**Subject:** Rezoning Petition Review

**Date of Review:** January 27, 2022 *(Revised March 21, 2022)*

**Rezoning Petition #:** 21-209

**Location of Property:** Approximately 1.66 acres located at the southeast intersection of Steele Creek Rd and Rigsby Rd, north of Dixie River Rd.

RZ1.0

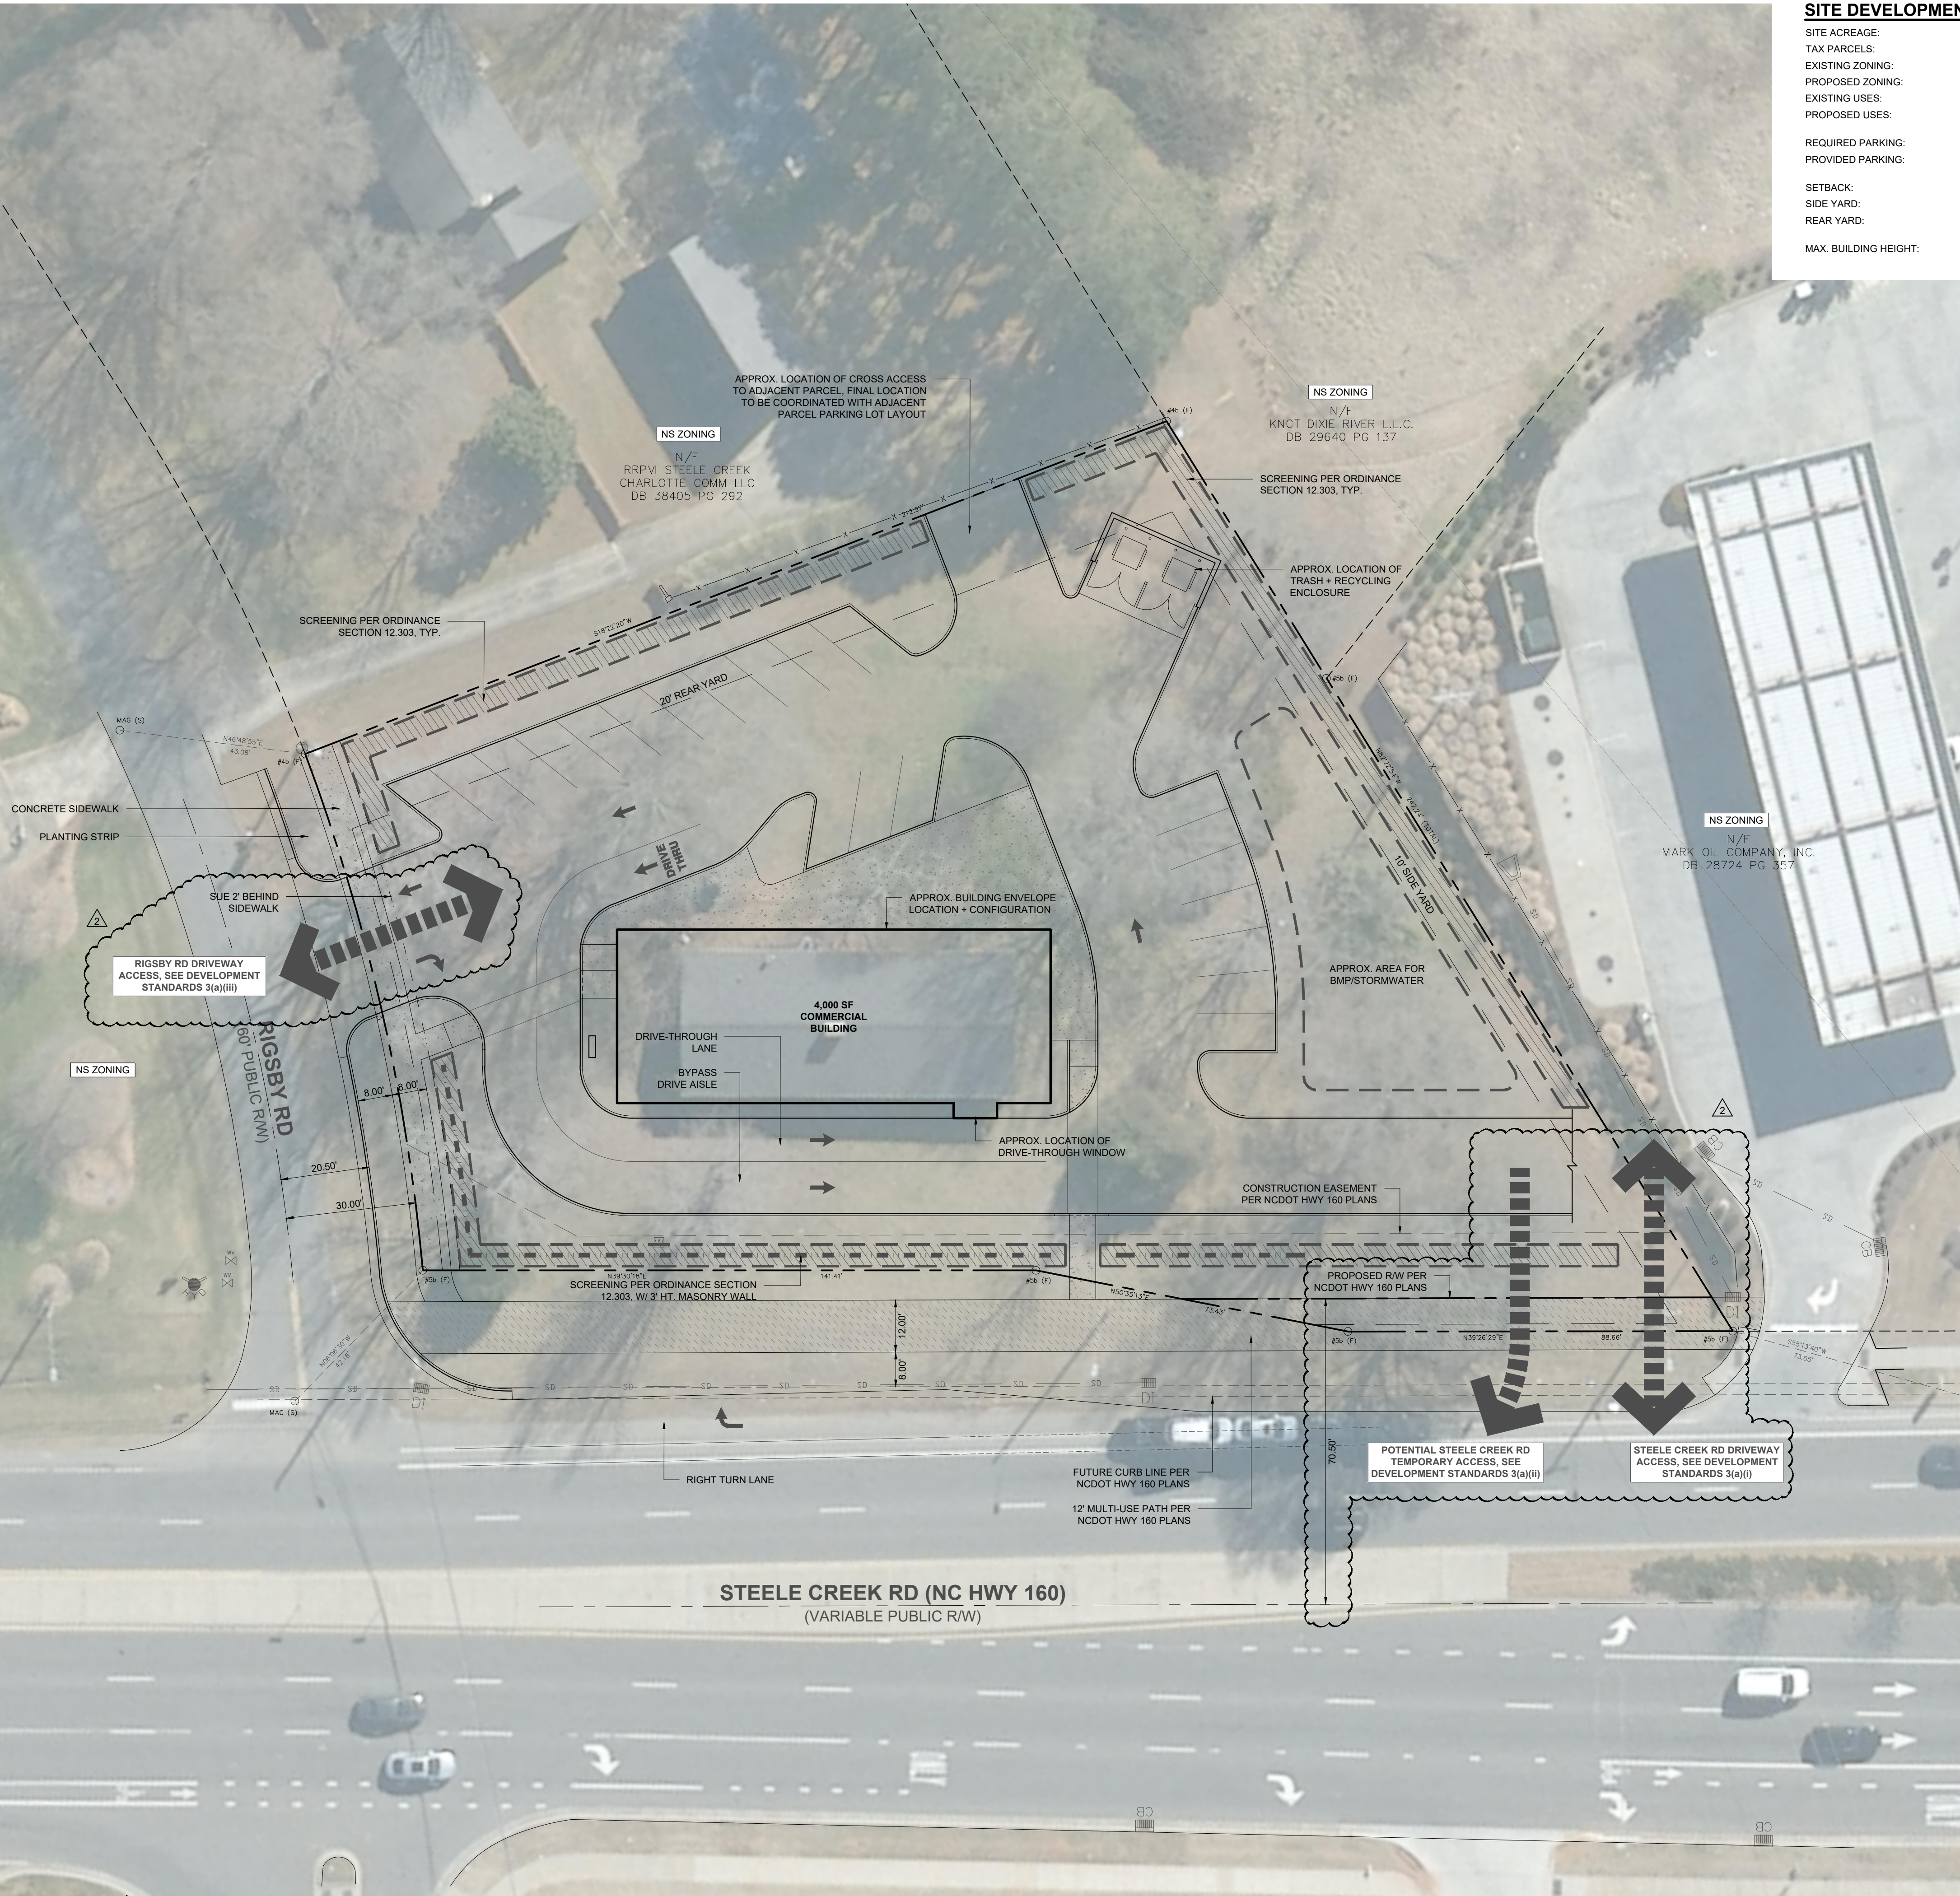
The proposed rezoning plan sheet indicates a proposed location for storm water management. Please include the following notes on the plan sheet under "Environmental Features": The location, size, and type of storm water management systems depicted on the Rezoning Plan are subject to review and approval as part of the full development plan submittal and are not implicitly approved with this rezoning. Adjustments may be necessary in order to accommodate actual storm water treatment requirements and natural site discharge points.

**This property drains to Beaverdam Creek, which is an impaired/degraded stream, and may contribute to downstream flooding. This project has the opportunity to mitigate future impacts to this stream, therefore, Storm Water recommends placing the following notes on the plan:**

#### (I) Storm Water Quality Treatment

For defined watersheds greater than 12% built-upon area (BUA), construct water quality stormwater control measures (SCMs) designed for the runoff generated from the first 1-inch of rainfall for all new and redeveloped BUA associated with the project. SCMs must be designed and constructed in accordance with the Charlotte-Mecklenburg BMP Design Manual.

#### (II) Volume and Peak Control

For defined watersheds greater than 12% built-upon area, control the entire volume for the 1-year, 24-hour storm for all new and redeveloped BUA associated with the project. Runoff volume drawdown time shall be in accordance with the Charlotte-Mecklenburg BMP Design Manual.

For commercial projects with greater than 12% BUA, control the peak to not exceed the predevelopment runoff rates for the 10-yr, 6-hr storm and perform a downstream flood analysis to determine whether additional peak control is needed and if so, for what level of storm frequency, or if a downstream analysis is not performed, control the peak for the 10-yr and 25-yr, 6-hour storms.

For residential projects with greater than 12% BUA, control the peak to not exceed the predevelopment runoff rates for the 10-year and 25-year, 6-hour storms or perform a downstream analysis to determine whether peak control is needed, and if so, for what level of storm frequency.
